**WELWYN HATFIELD BOROUGH COUNCIL
EXECUTIVE DIRECTOR - PLANNING, PUBLIC PROTECTION AND GOVERNANCE**

Application No: 6/2021/1179/EM
Location: 25 Rooks Hill Welwyn Garden City AL8 6EU
Proposal: Erection of rear single-storey extension with roof lights in order to create extended family/kitchen area with utility and associated works.
Officer: Mr James Homer

Recommendation: Refused

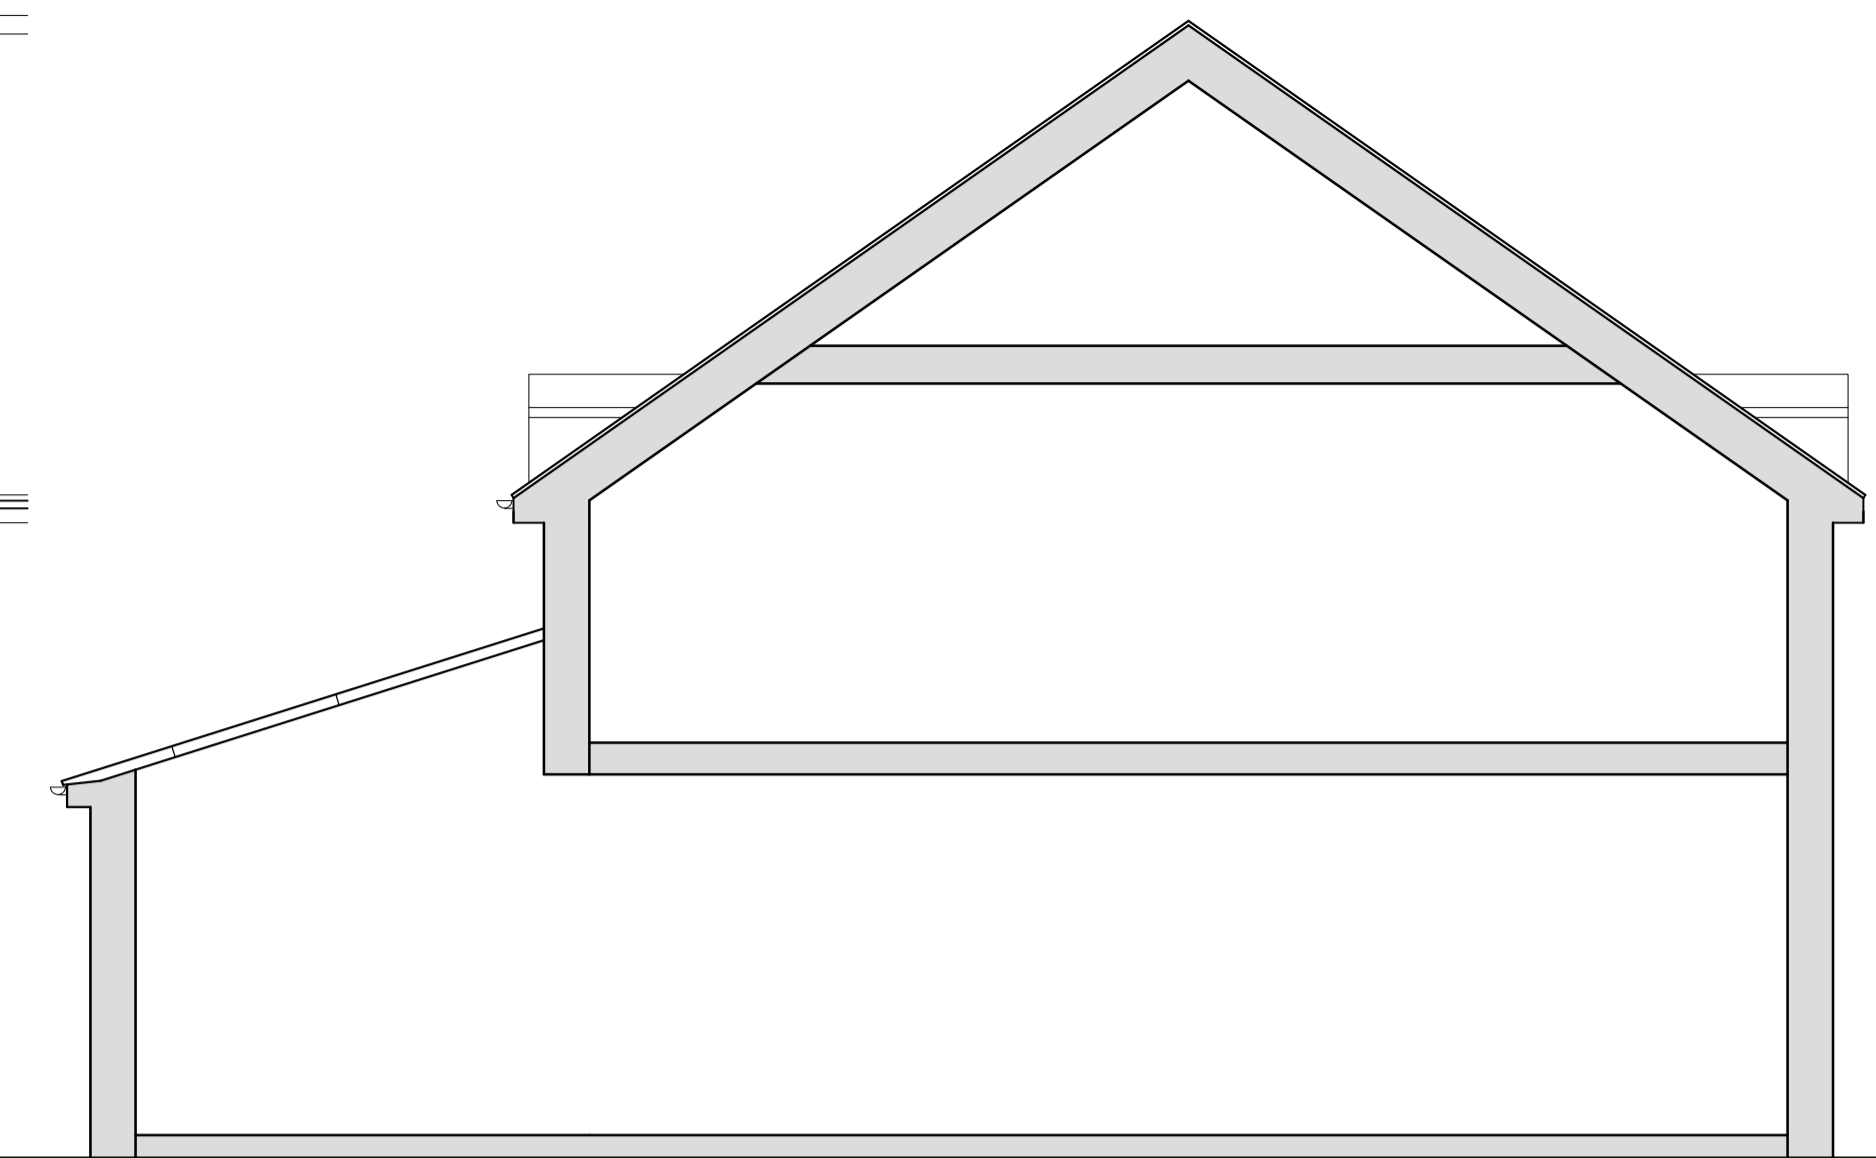
1. Although the depth and width of the proposed extension may be considered acceptable, the mono pitched roof is contrary to Estate Management Scheme guidance. Single storey rear extensions are expected to accommodate a flat roof system to help maintain a feeling of openness within the Estate Management Scheme area and minimise the disruption to the design of the original building. As a result, the application fails to comply with Policy EM1 of the Estate Management Scheme.
